**SUBMISSION FOLLOWING THE REQUEST FROM DEPARTMENT OF PLANNING, INDUSTRY and ENVIRONMENT
regarding the Marist Catholic College North Shore-**

We are residents of Carlow Street North Sydney and desire to provide details of our intense concerns regarding the Development Application SSD-10473 for the redevelopment of Marist College on the corner of Miller and Carlow Streets. Earlier this year many residents submitted details of objections and suggestions to be considered by NSW Planning and the Applicant but there have been no significant amendments to ameliorate the proposed design. The questions raised in our letter submission dated 19 March 2021 still need to be considered and answered.

Appendix A: General Waste & Recycling Storage

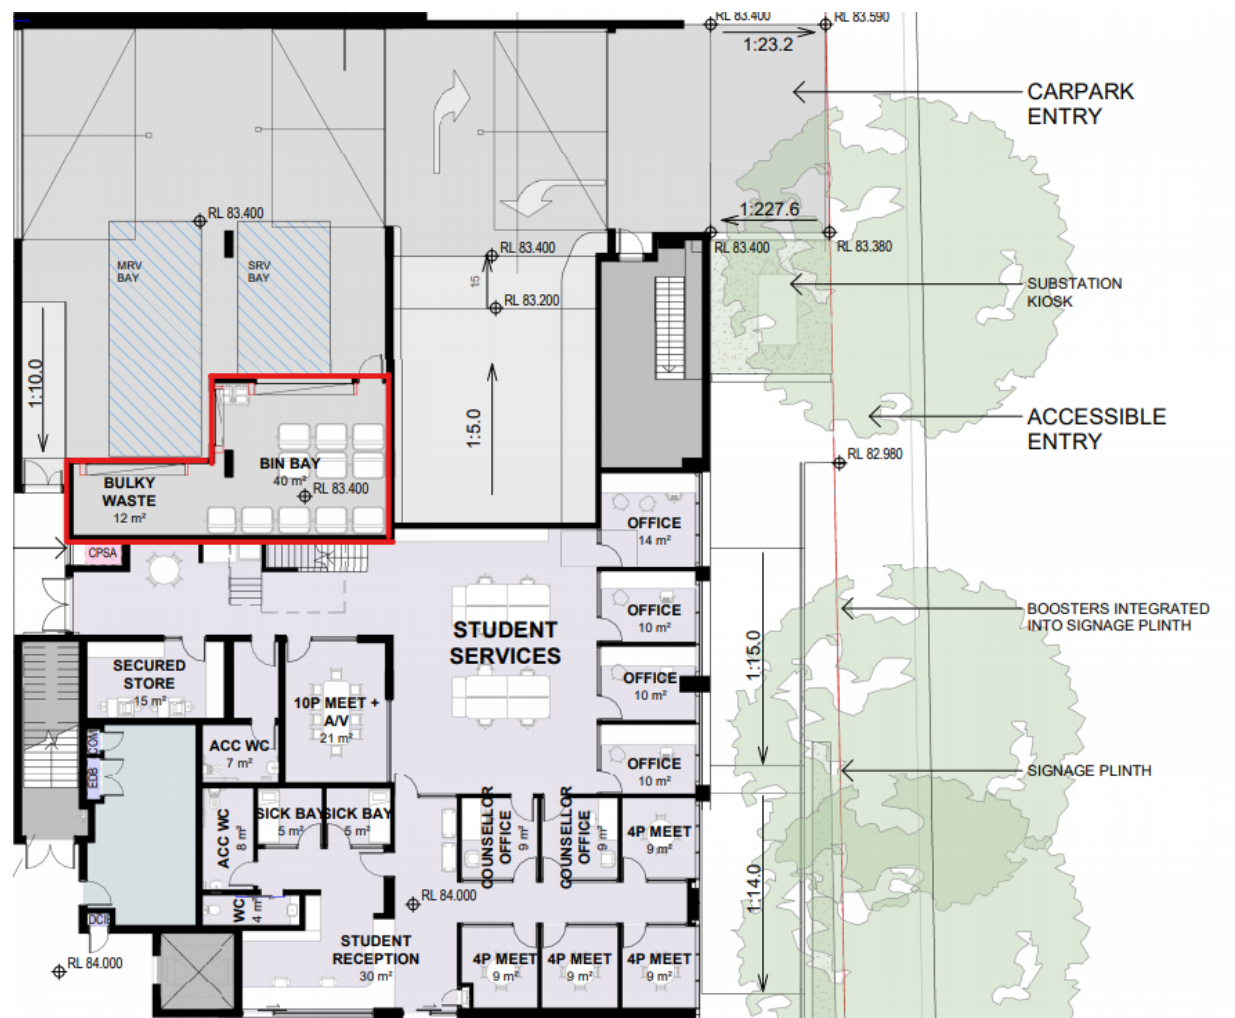
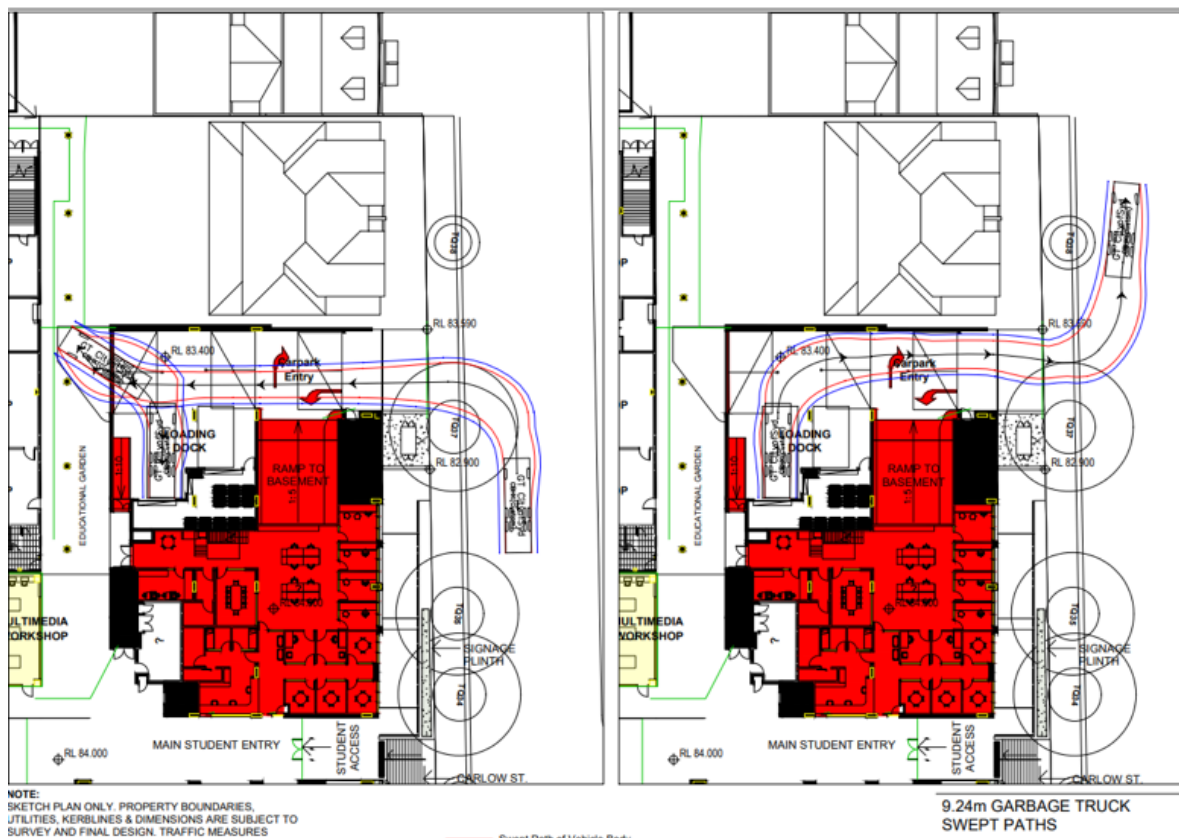
3. The relocating of the existing main traffic flow entry and exit including garbage collection from the development to Carlow Street which is residential. The development should use the present vehicle entry and exit locations to Miller and Ridge Streets. These are located opposite existing commercial areas and buildings.

2 CARLOW ST SECTION

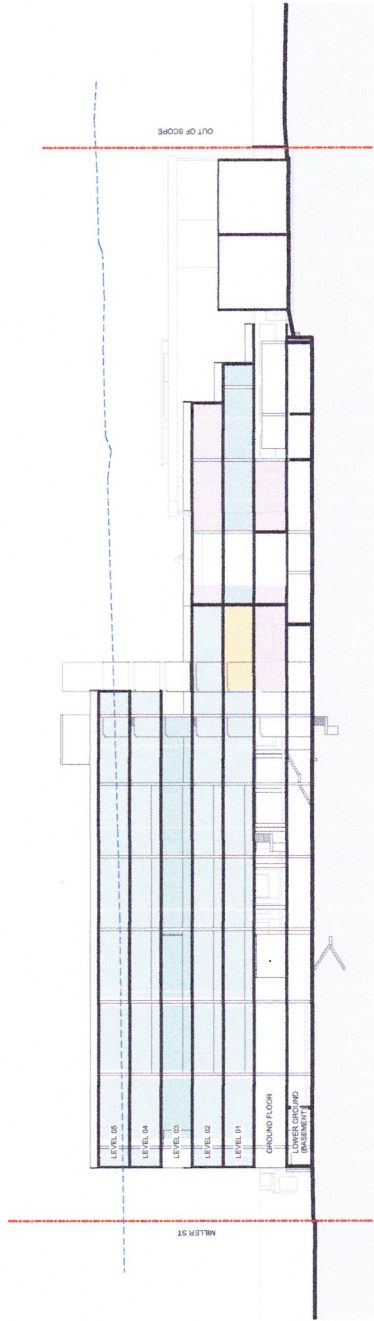
5. The proposed building along Carlow Street is inappropriately scaled in height and an unsympathetic addition to existing street landscape. Our residential area in the North Sydney Council zoned Holtermann Estate Conservation Area has a maximum two-storey building height. All other buildings are restricted to 12 metres in height with 6 metres in setback.
